Broadland District Council Response to Examining Authority's Written Questions (ExQ1)

Deadline 1 (6th July 2021)

**MASTERPLAN**

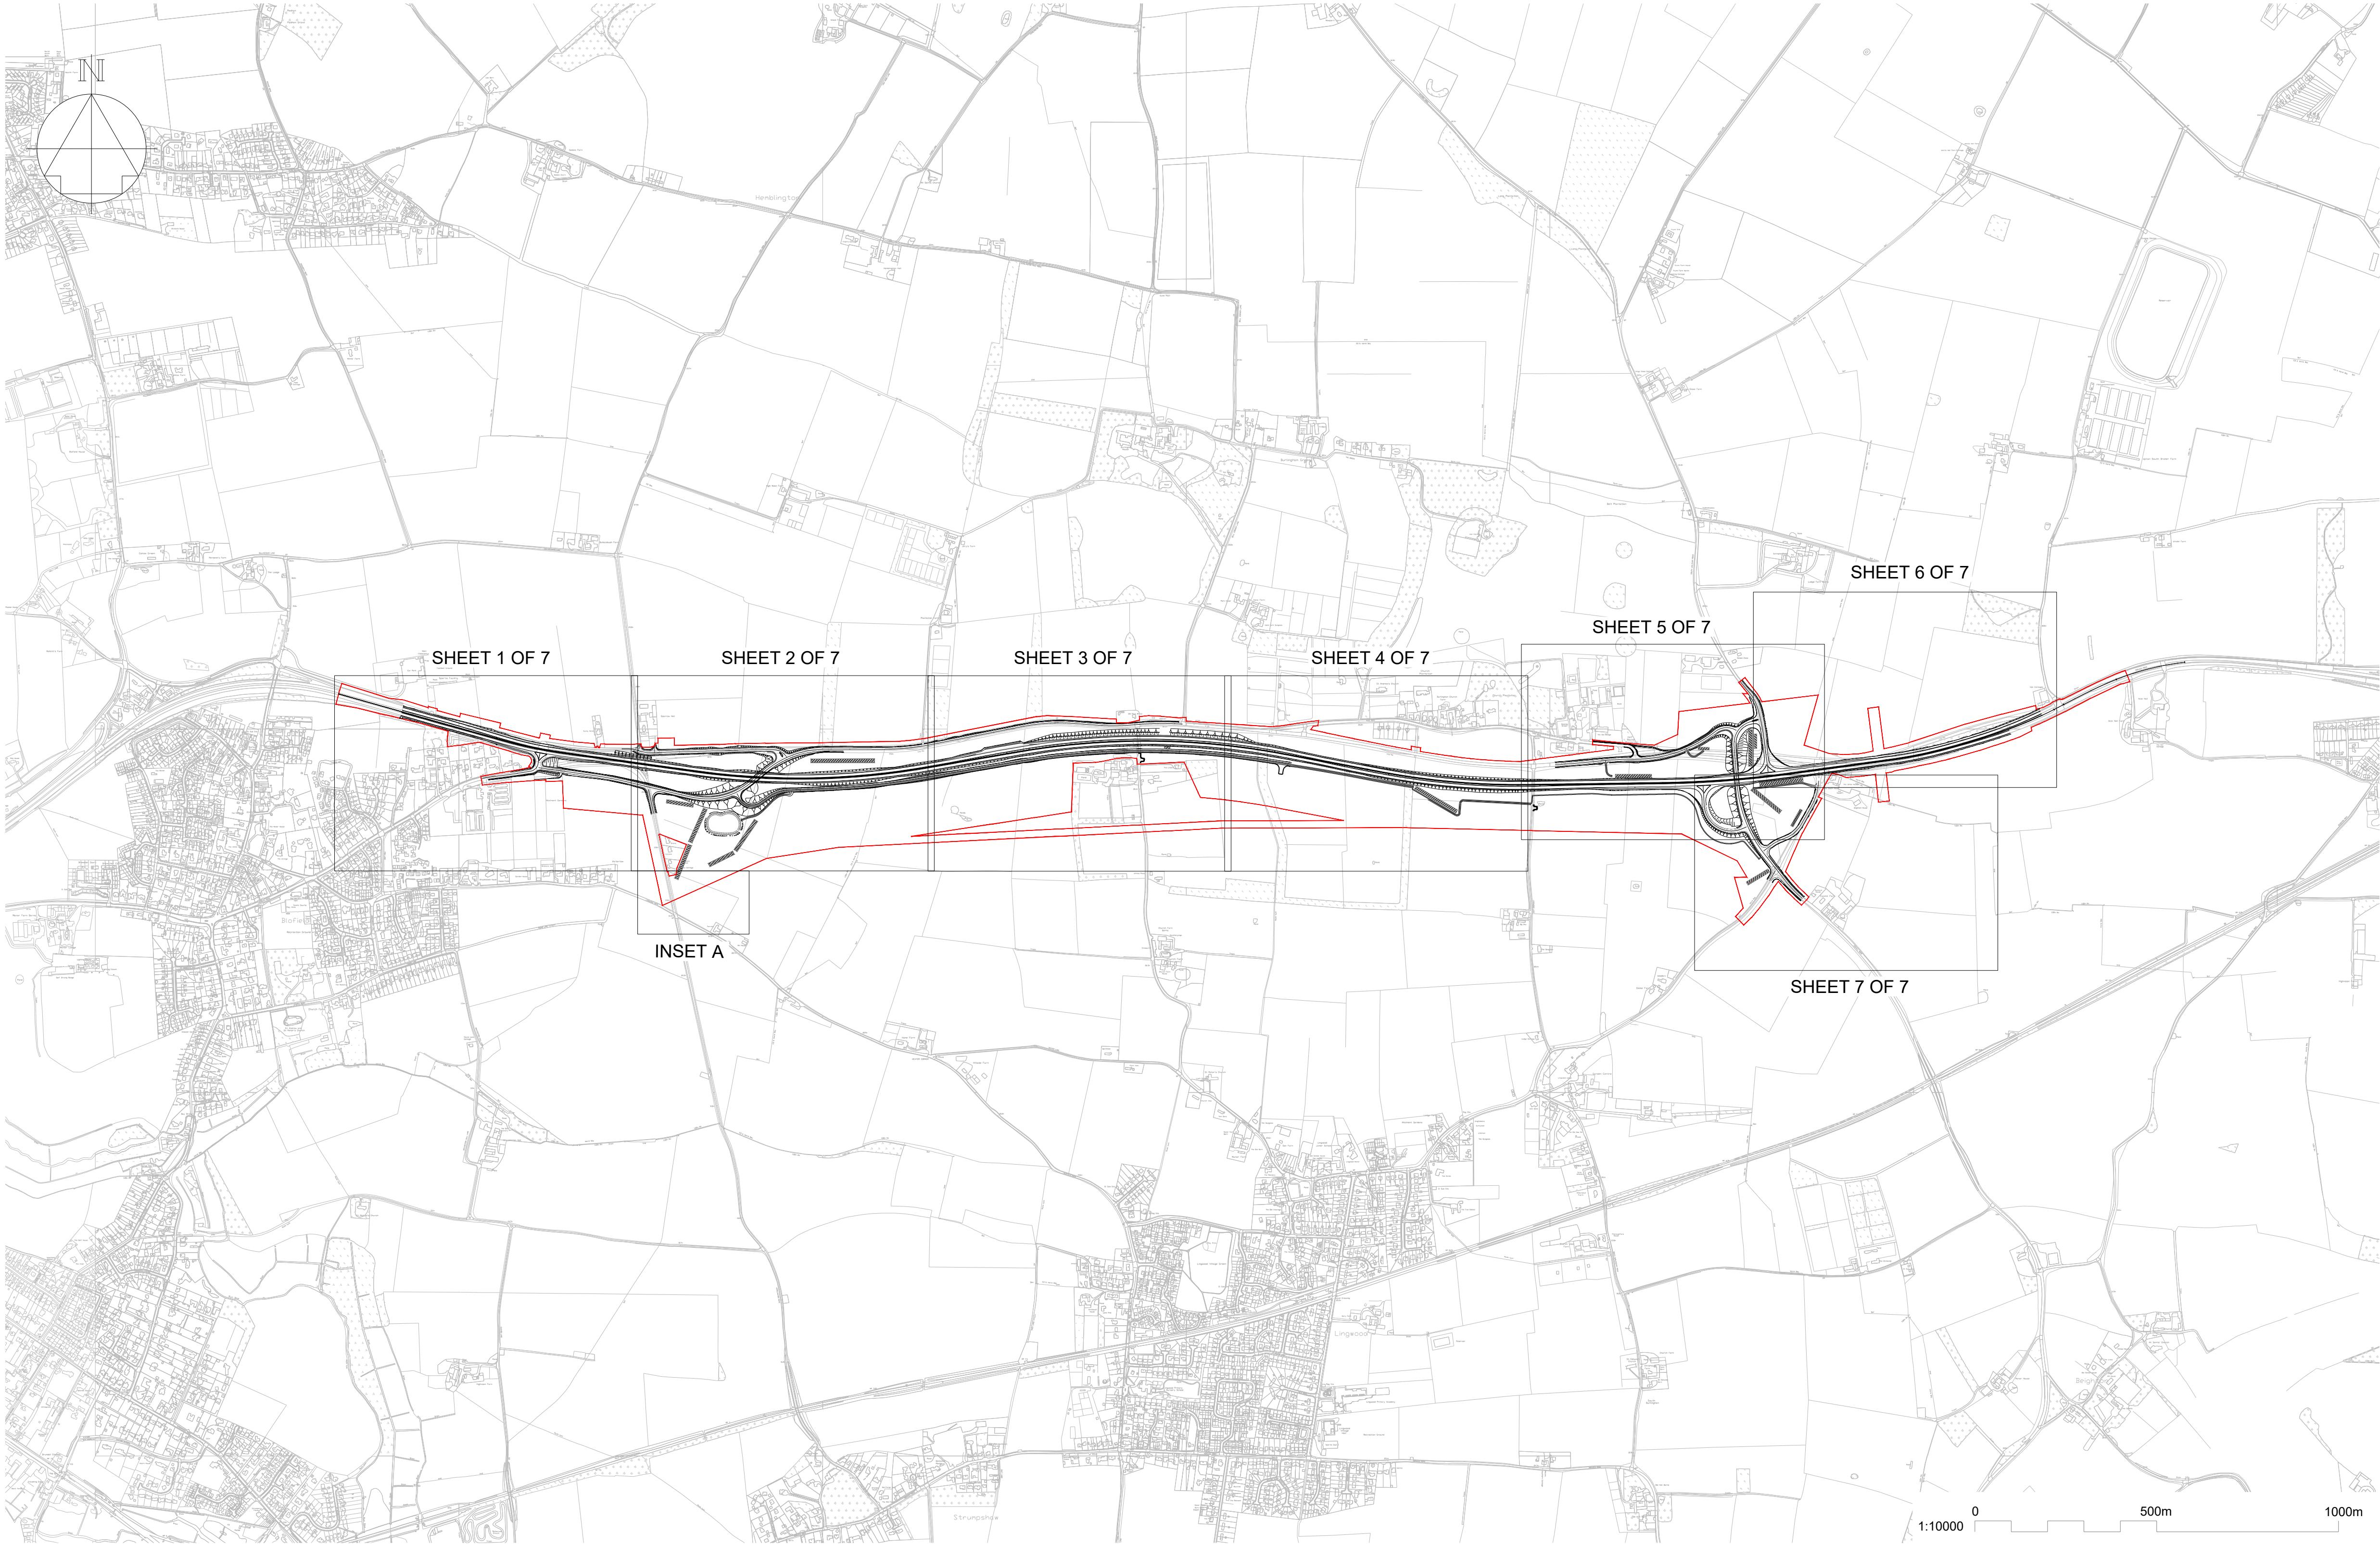
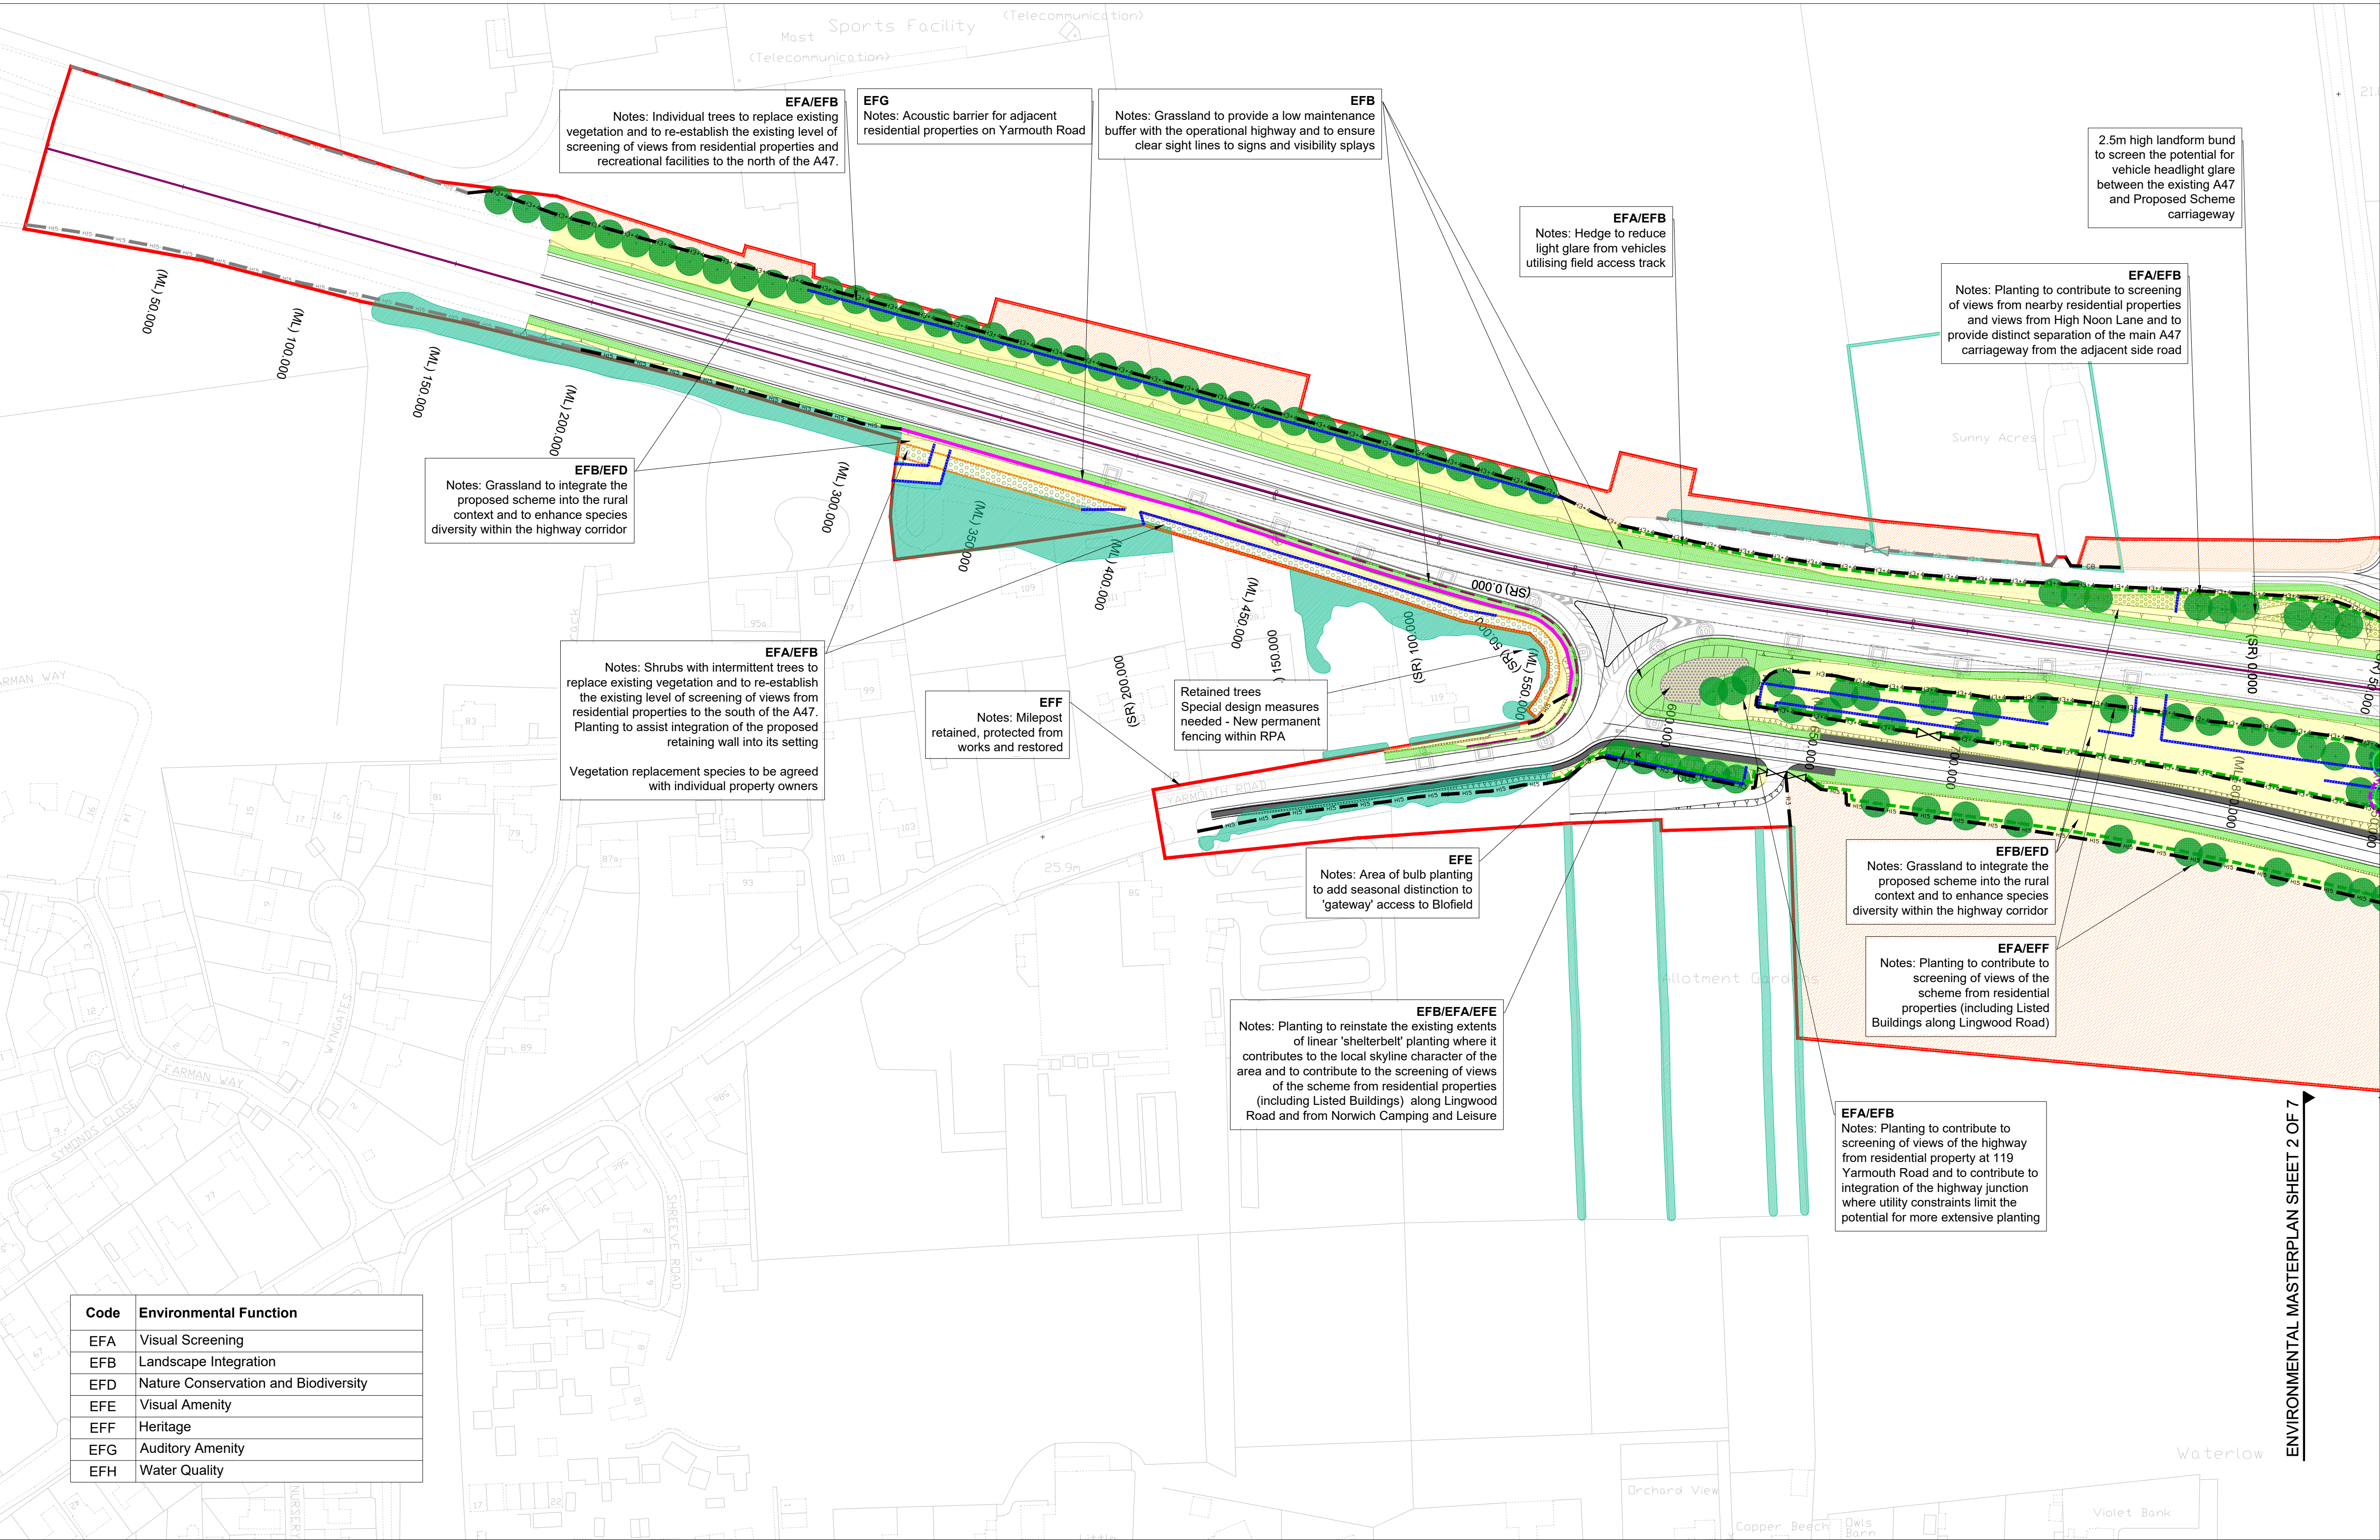
1.10.2	Is BDC and NCC satisfied with the Masterplan [APP-118] and the proposed species mix as shown on the final page of the Masterplan?	BDC have no reasons to dispute the spatial arrangement and general design of the planting proposals.

BDC would query the use of ivy (<i>Hedera helix</i>) and Blackberry (<i>Rubus fruticosus</i>); these are potentially quite dominating of young woody planting, and can be problematic in mature hedgerows and plantings. Whilst there is no disputing the important habitat and food sources these species can provide, it might be that they are best introduced as part of management, rather within the initial mix.
